**Consultation Response from KC,
Highways Development Management**

2025/92713 Rear of, 23 to 43, Moor Lane, Gomersal, Cleckheaton, BD19 4LF

Date Responded: 18-11-2025

PROPOSED SITE PLAN 1:200 @ A1

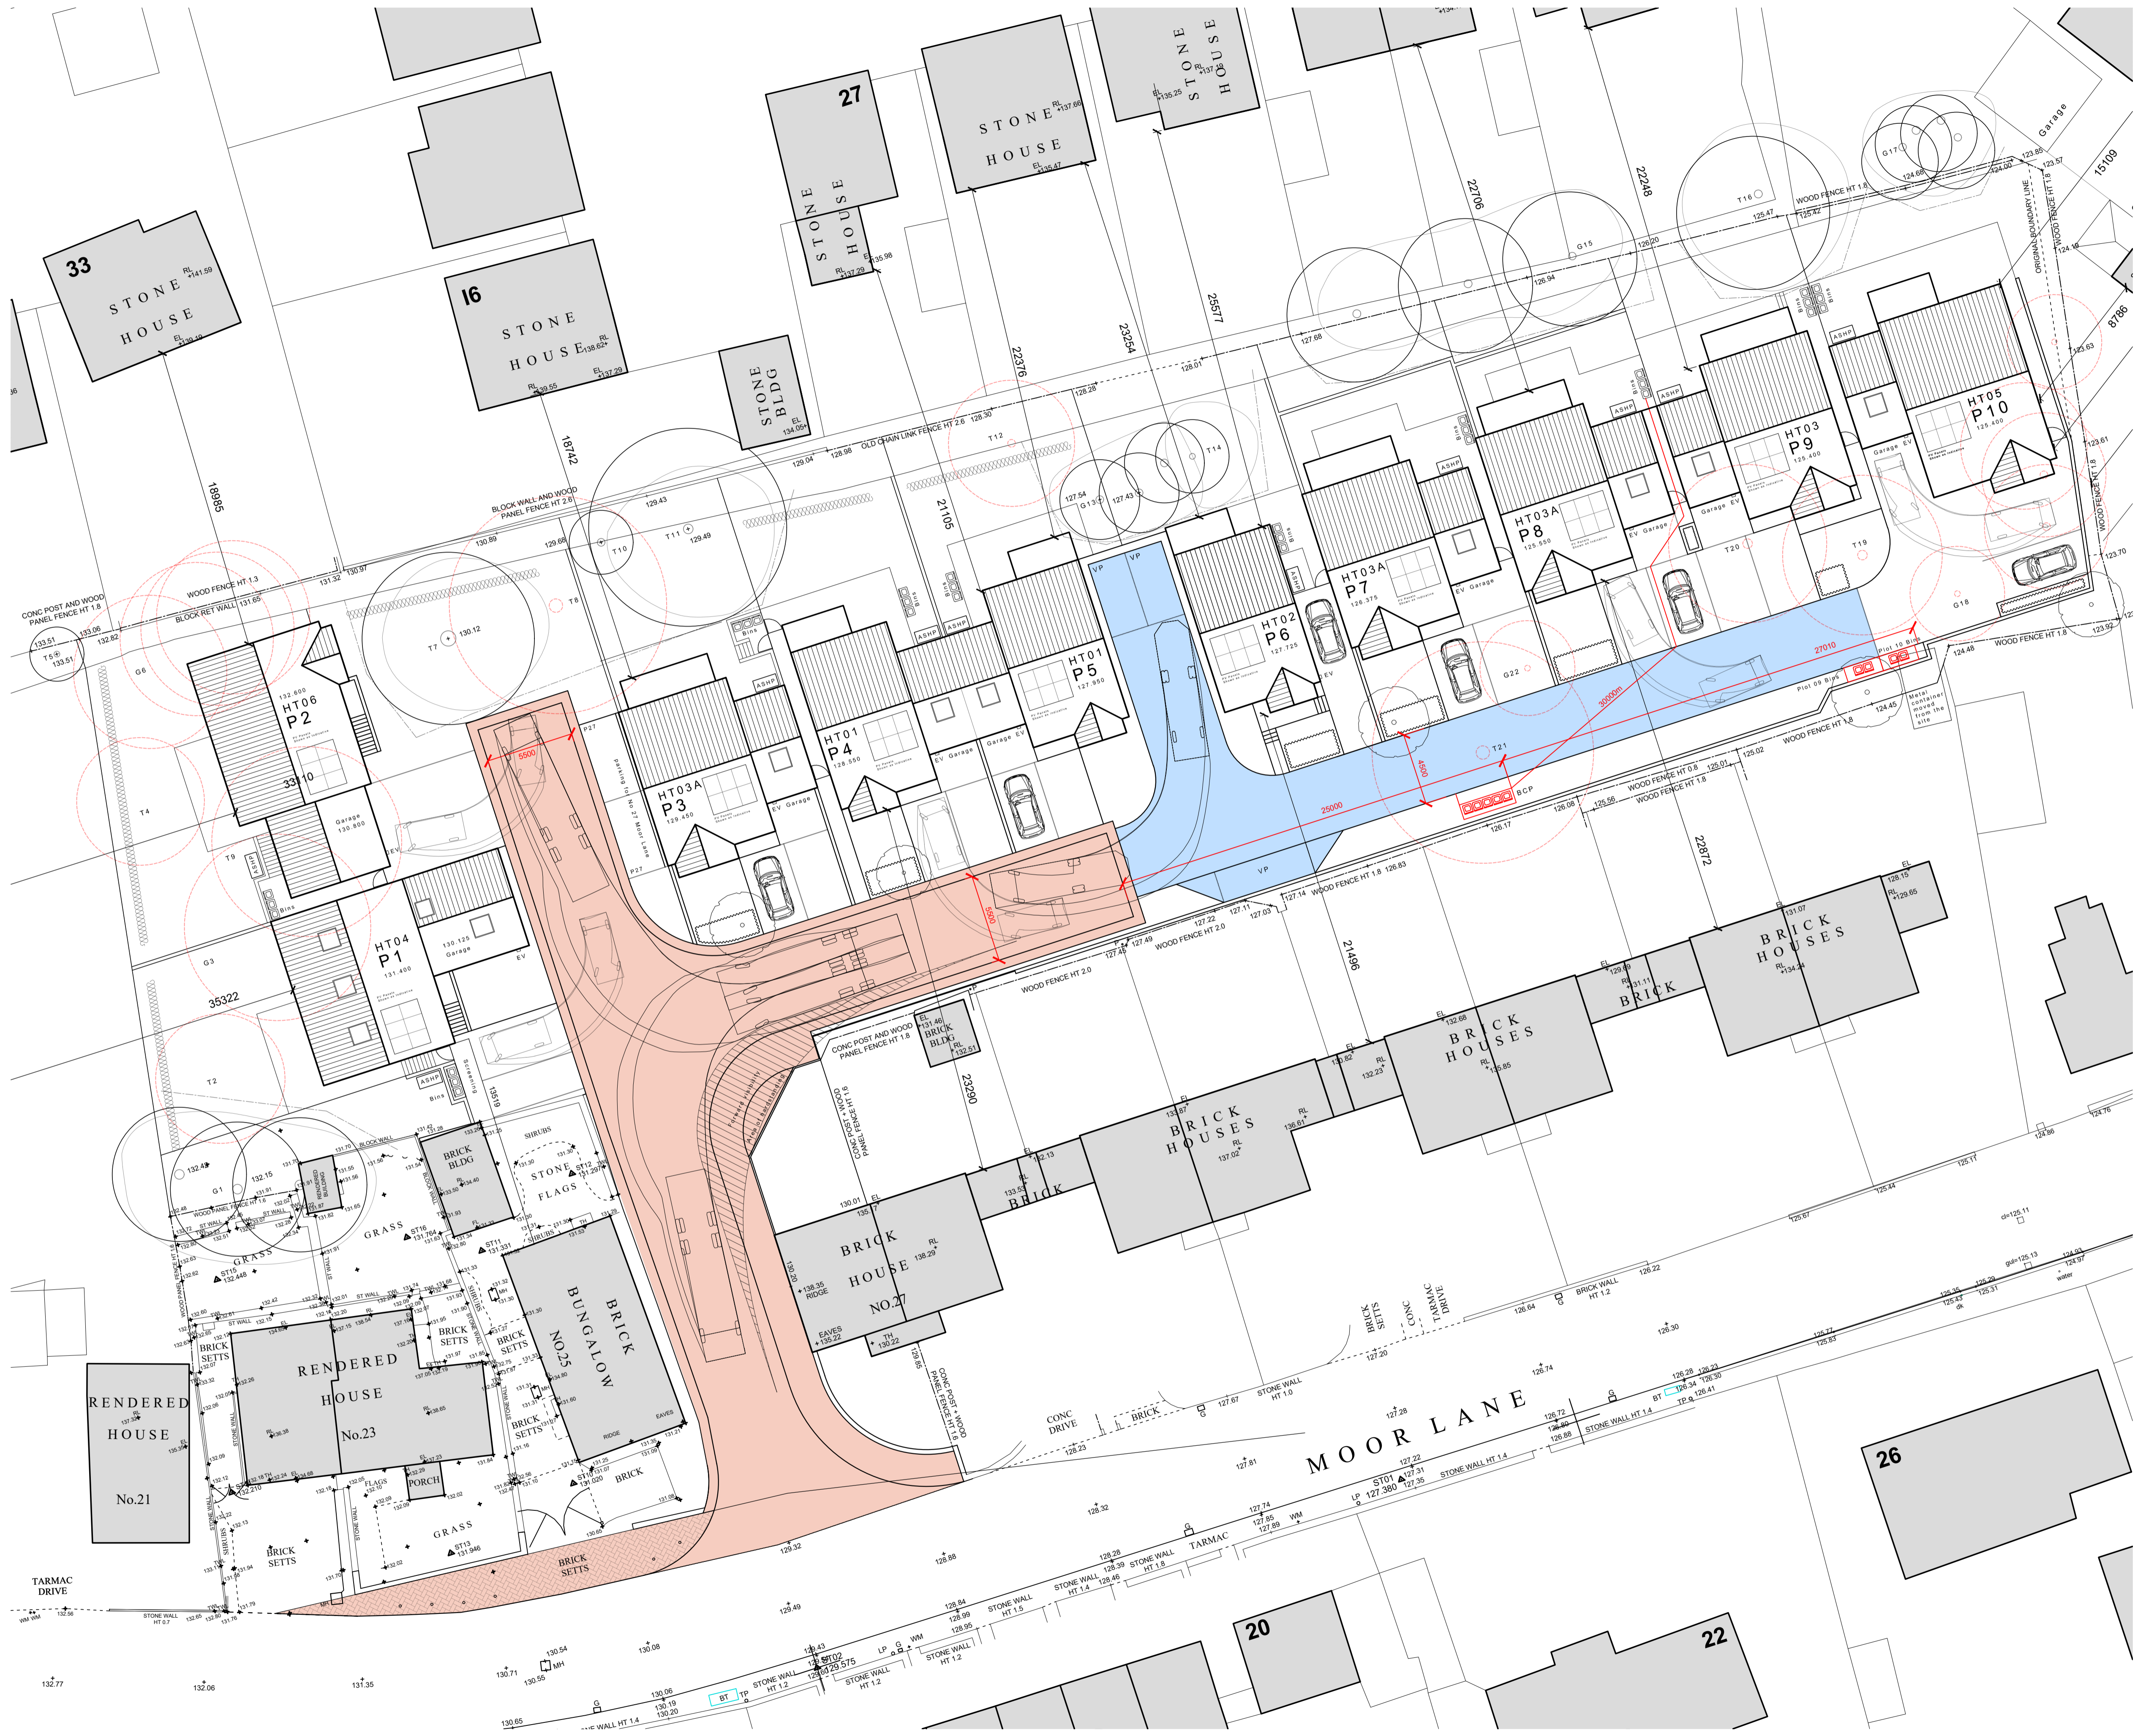
1, Two parking spaces are shown on the proposed site plan number 002 rev C for P27. Can it be confirmed that these spaces are to be allocated to house number 27 Moor Lane to compensate for loss of parking to the dwelling.

2, The forward visibility splay to the first bend is not clearly shown. The footway needs to be widened to include this area.
